Holme Valley Parish Council

Planning applications lodged with Kirklees from **21 09 2022** to **25 10 2022** - **List 2223-06**. The following applications will be considered by Holme Valley Parish Council ahead of the Planning Committee meeting **31/10/2022**. Where appropriate, recommendations will be made to Kirklees Planning Services regarding whether or not they should be approved, but the final decisions will be taken by Kirklees Planning Services.

Rear Extension and Garage Conversion																				drawing number 210

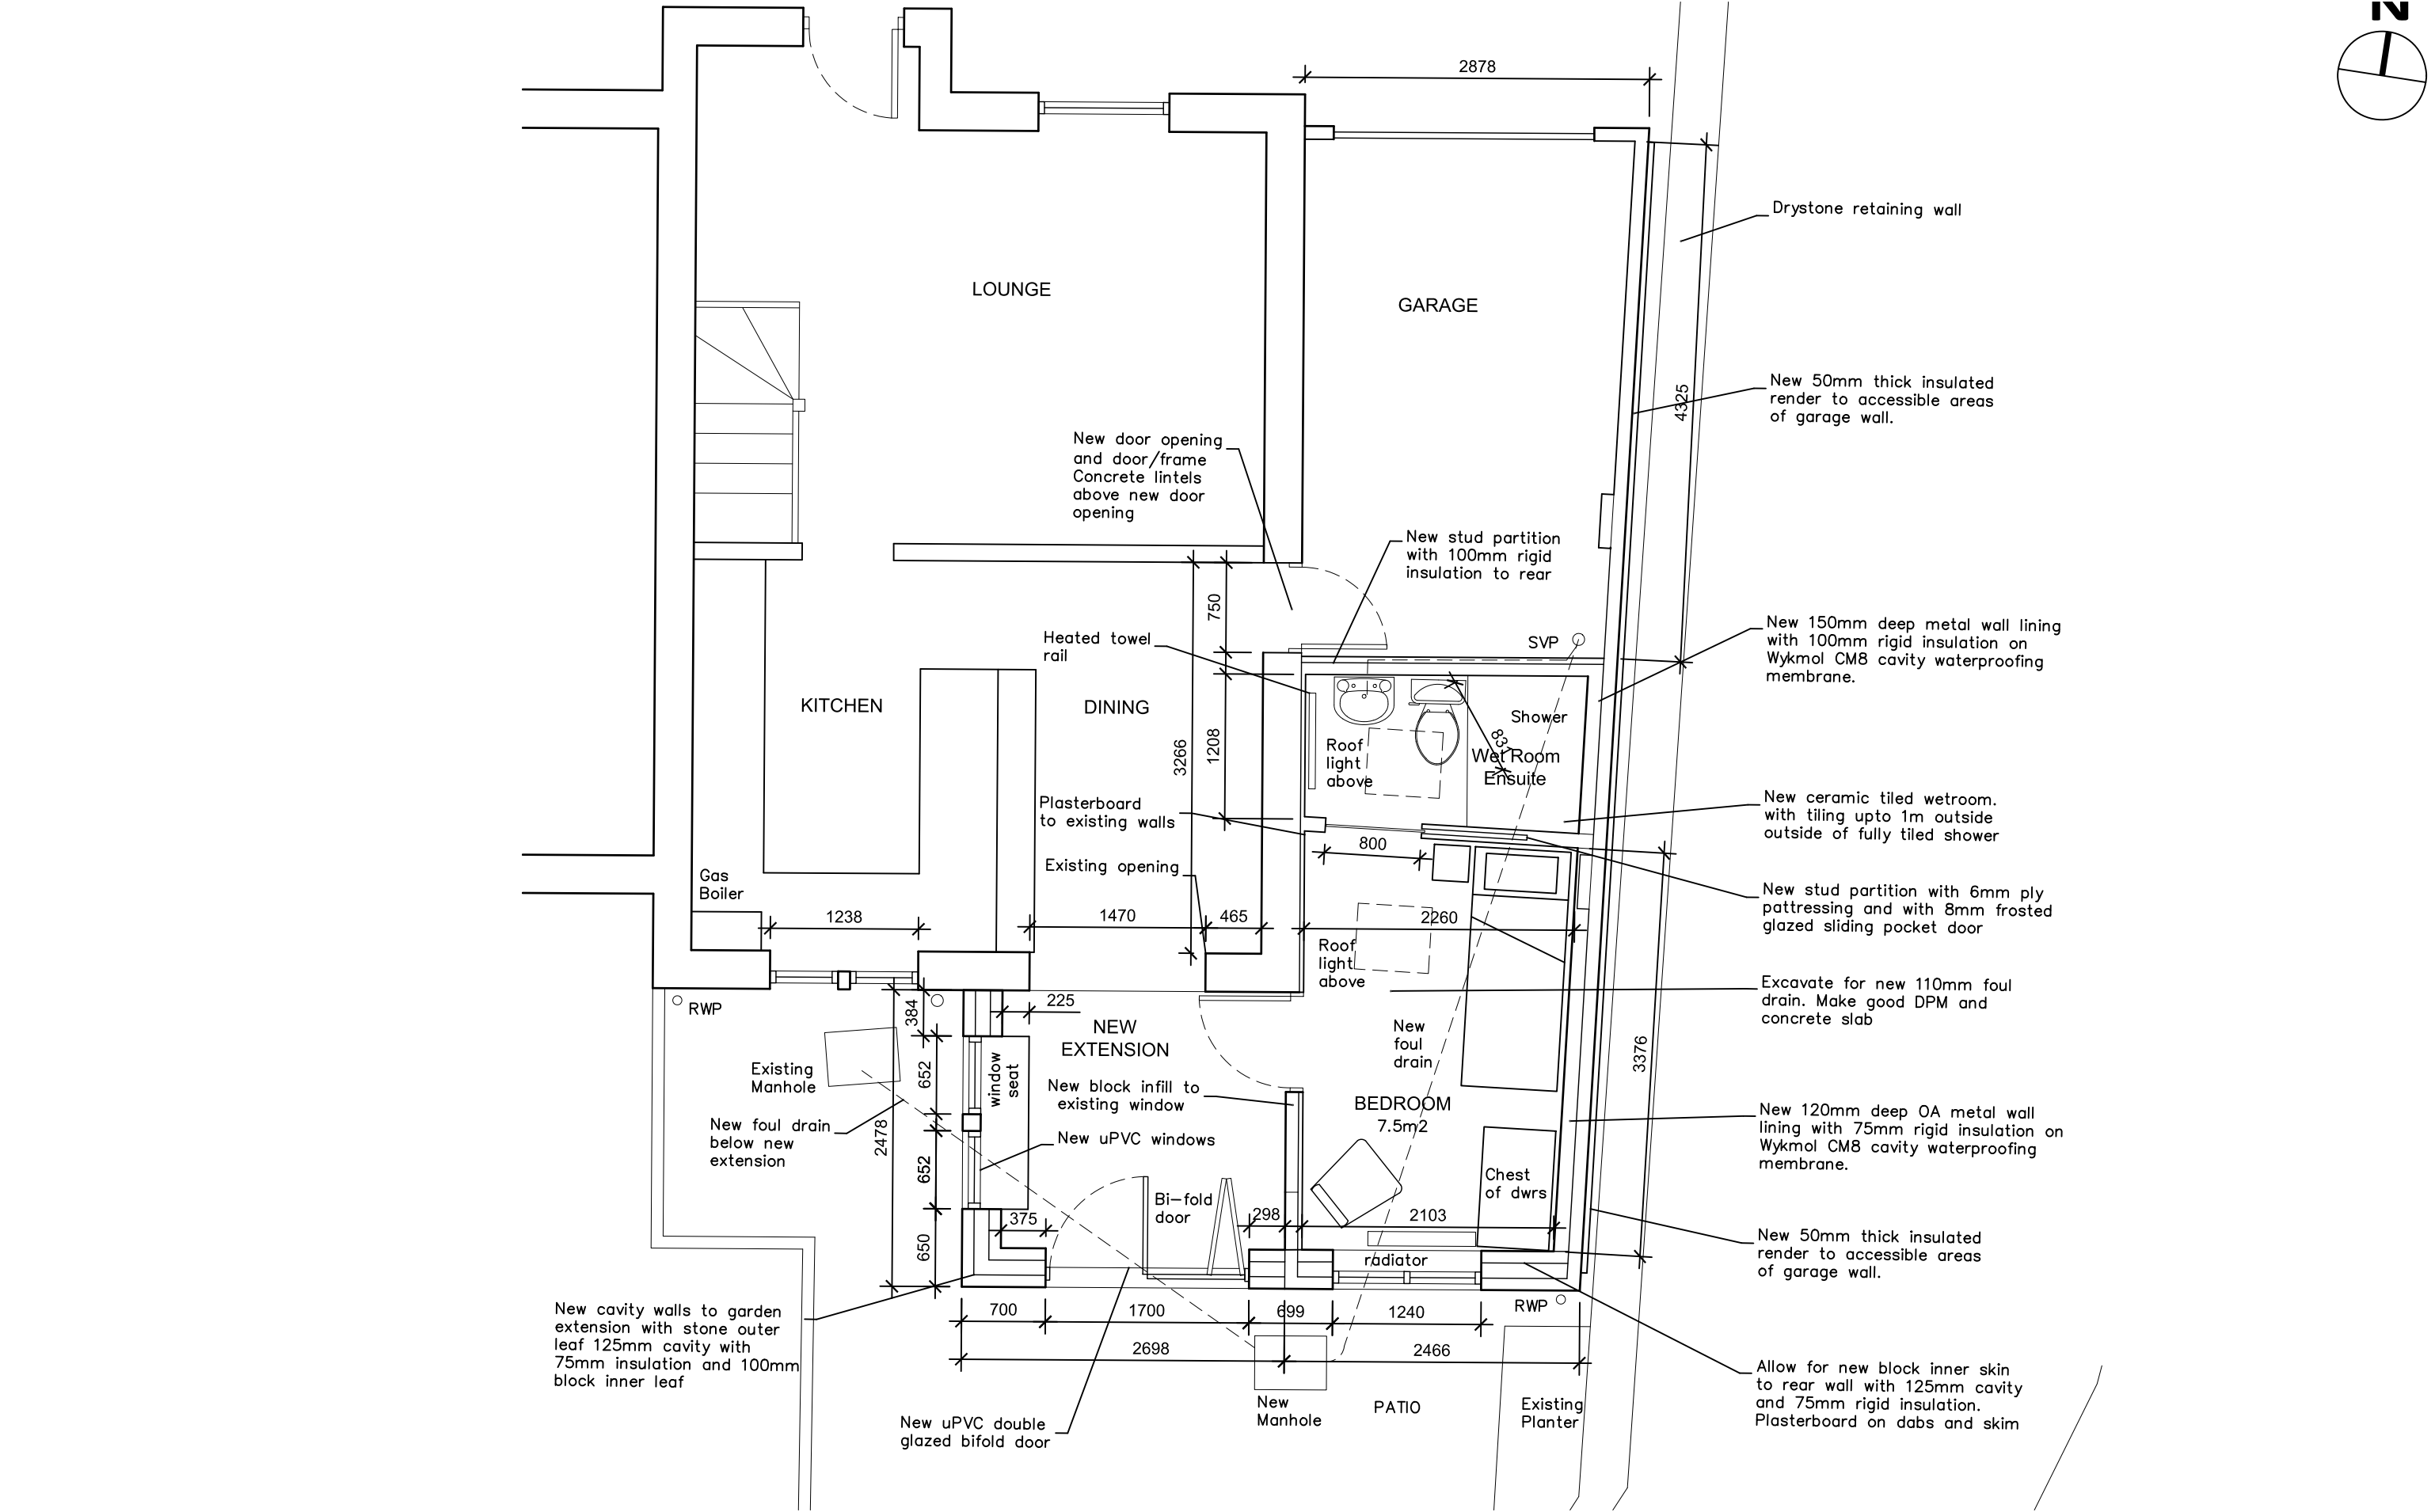
HVPC Reference:	2223/06/23
Application No:	2022/62/93128/W
Proposed Development:	Alterations to convert part of garage to extend living accommodation and erection of single storey rear extension to replace glazed conservatory
Location:	2, Bayfield Close, Hade Edge, Holmfirth, HD9 2QX
OS Map Ref:	
Link:	https://www.kirklees.gov.uk/beta/planning-applications/search-for-planning-applications/detail.aspx?id=2022/93128
Ward/Councillors:	Scholes - MBI RPD
HVPC Comment:	Object on the basis of insufficient parking provision.
Decision:
